**CITY OF ALBUQUERQUE
PLANNING DEPARTMENT
January 22, 2014
DRB Comments**

PROJECT # 1009843

APPLICATION # 13-70001/ 70003

RE: Lot 20, Block 2, North Albuquerque Acres Tract 2 Unit 3

PLAT OF  
**JASMINE SUBDIVISION**  
 SITUATE WITHIN  
**PROJECTED SECTION 18**  
**T.11N., R.4E., N.M.P.M.**  
**ELENA GALLEGOS LAND GRANT**  
**CITY OF ALBUQUERQUE**  
**BERNALILLO COUNTY, NEW MEXICO**  
 JANUARY 2014

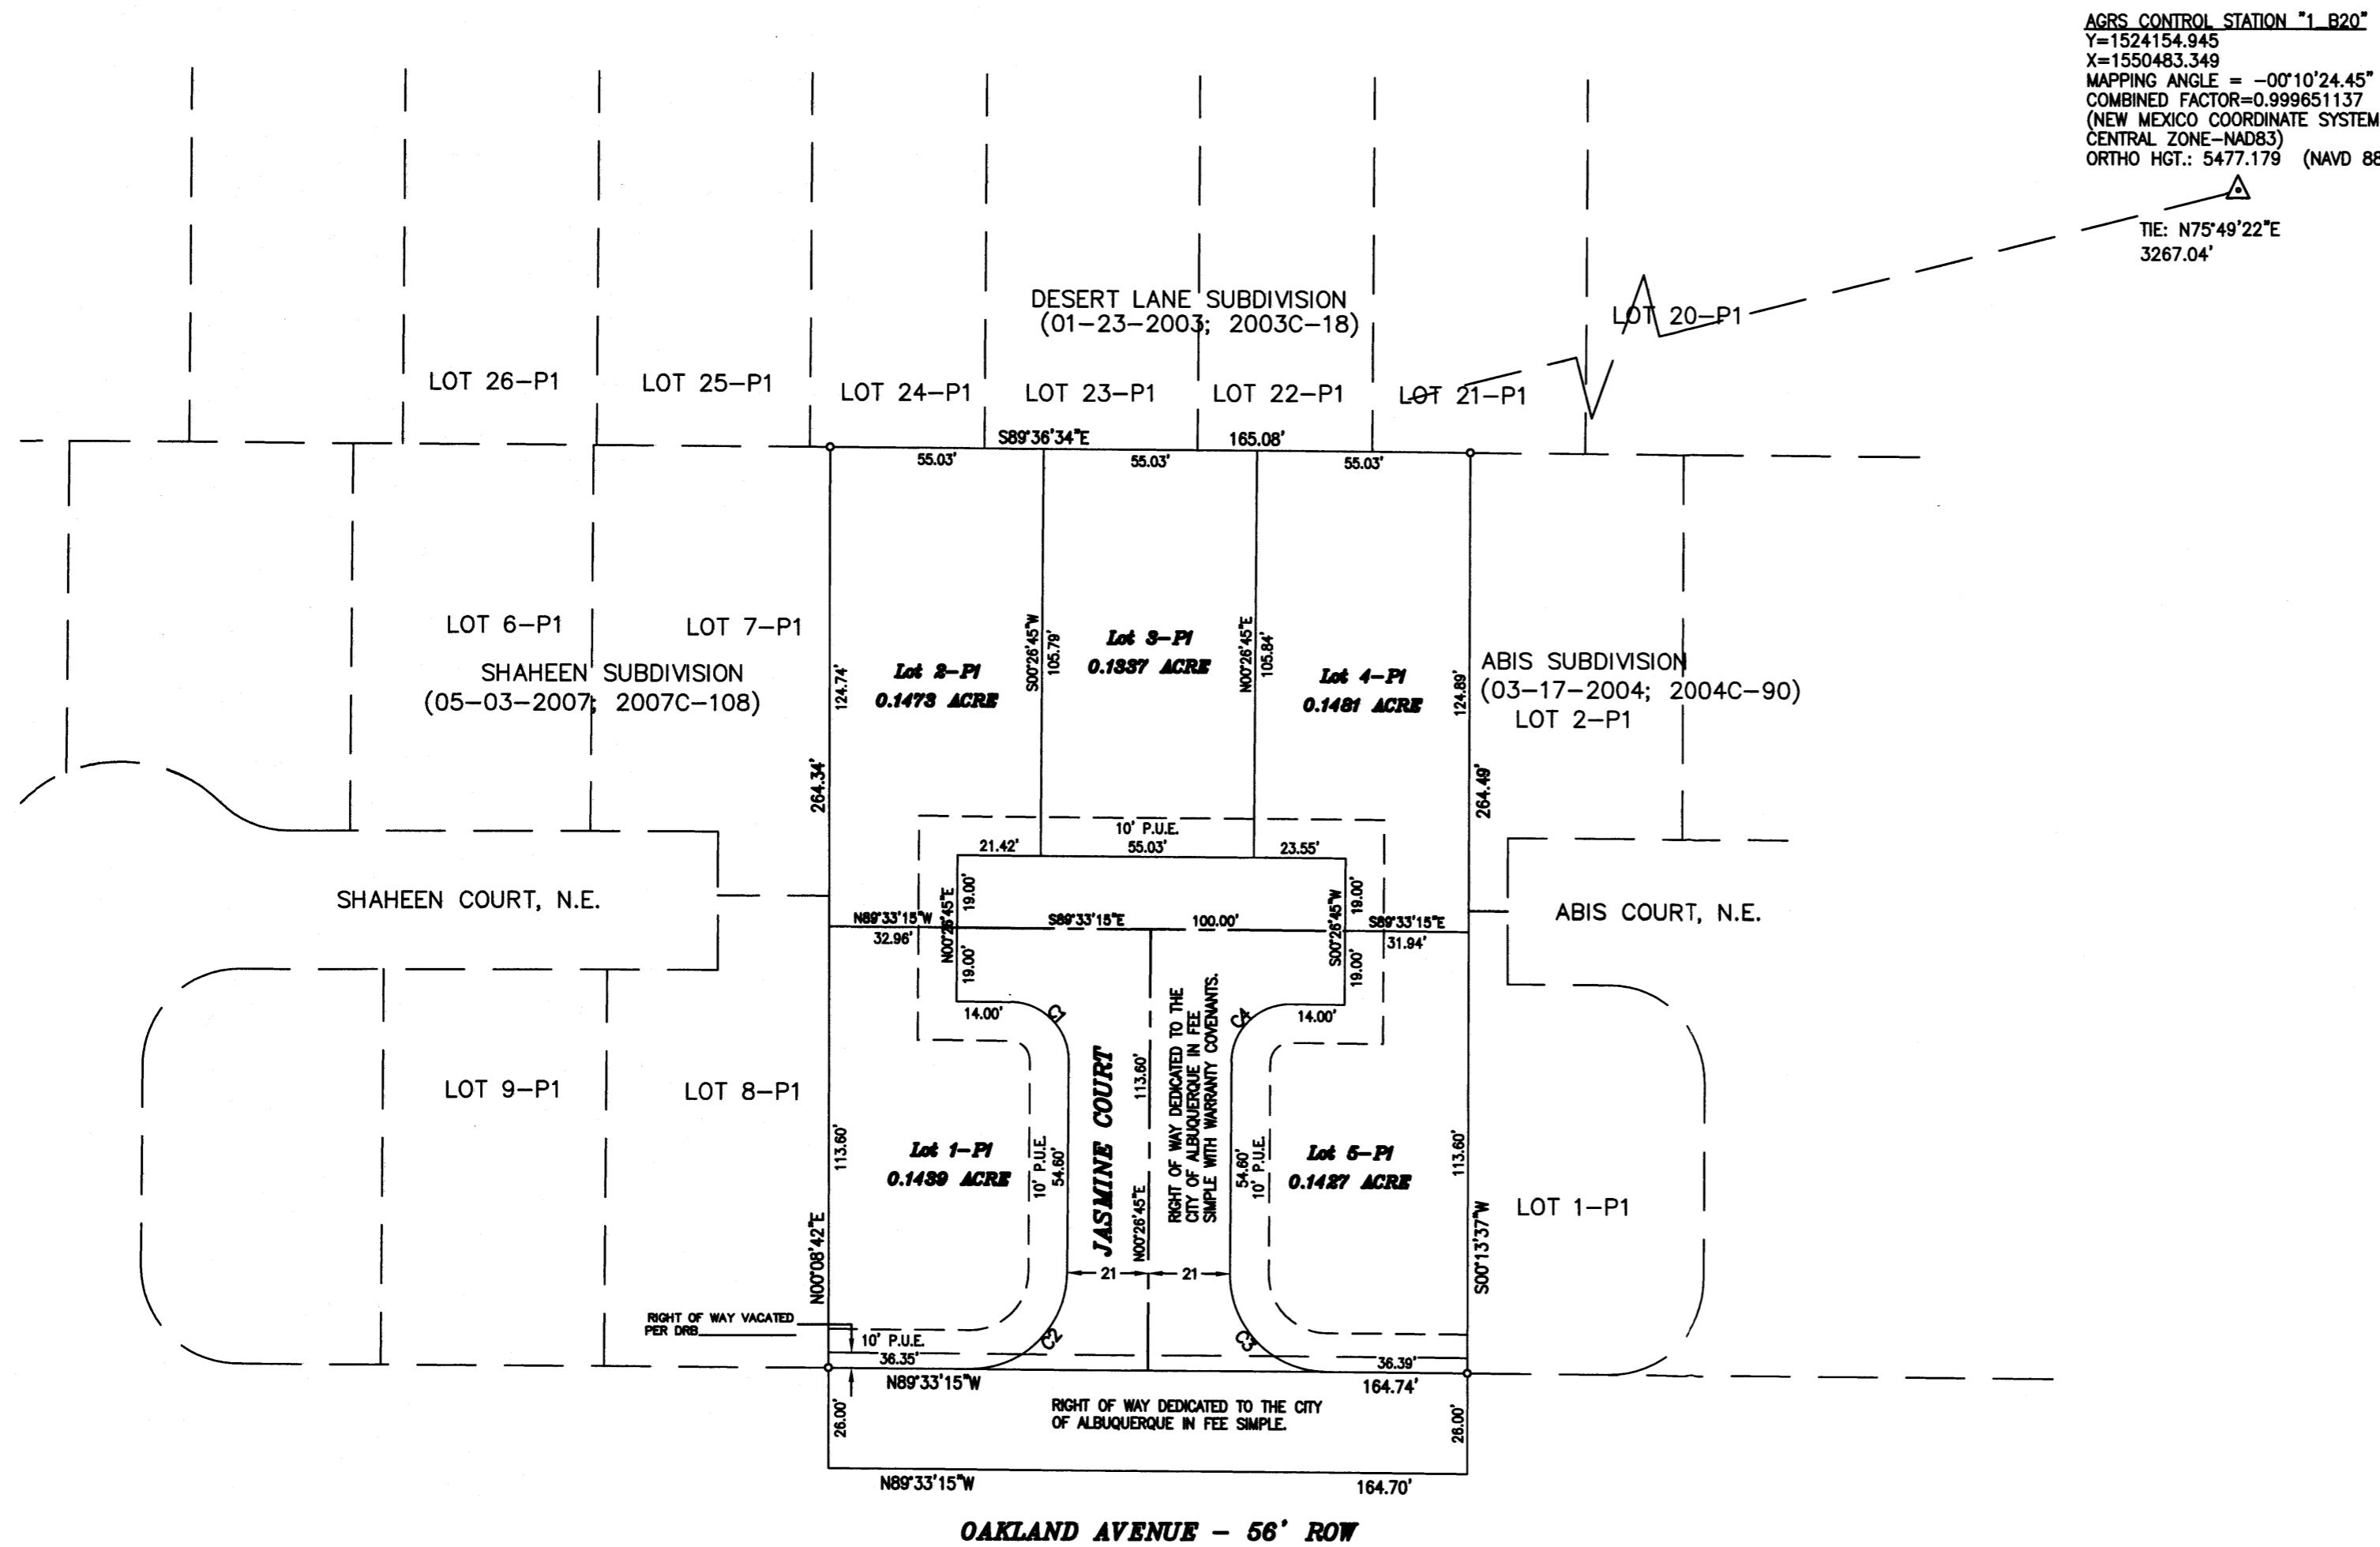
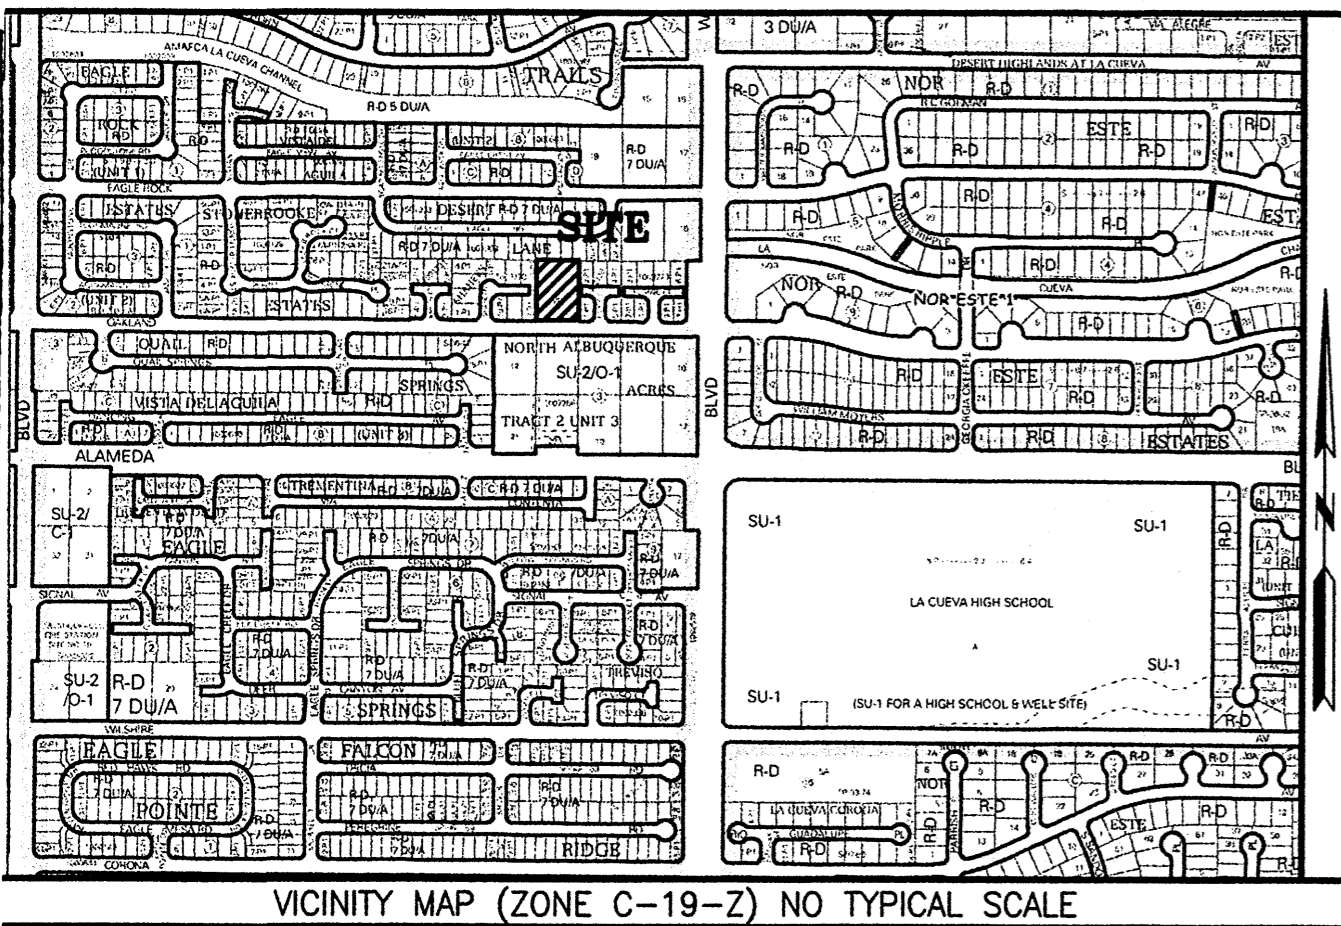
The proposed Design Variance does not appear to be in accordance with accepted principles of site planning for equitable pedestrian access. The Planning Department would consider reduced right of way to minimize sidewalk setback from the curb and allow two sidewalks back to the turnaround.

A recorded Subdivision Improvements Agreement/ SIA or completion and acceptance of infrastructure is required for Final Plat, as well as owners' and City Surveyor's approval and signature. Please remove Zoning Note (No. 5) from Final Plat.

Please note that maximum wall height in a residential zone is 8 feet and minimum pilaster projection is 2 inches; clear sight triangles need to be demonstrated.
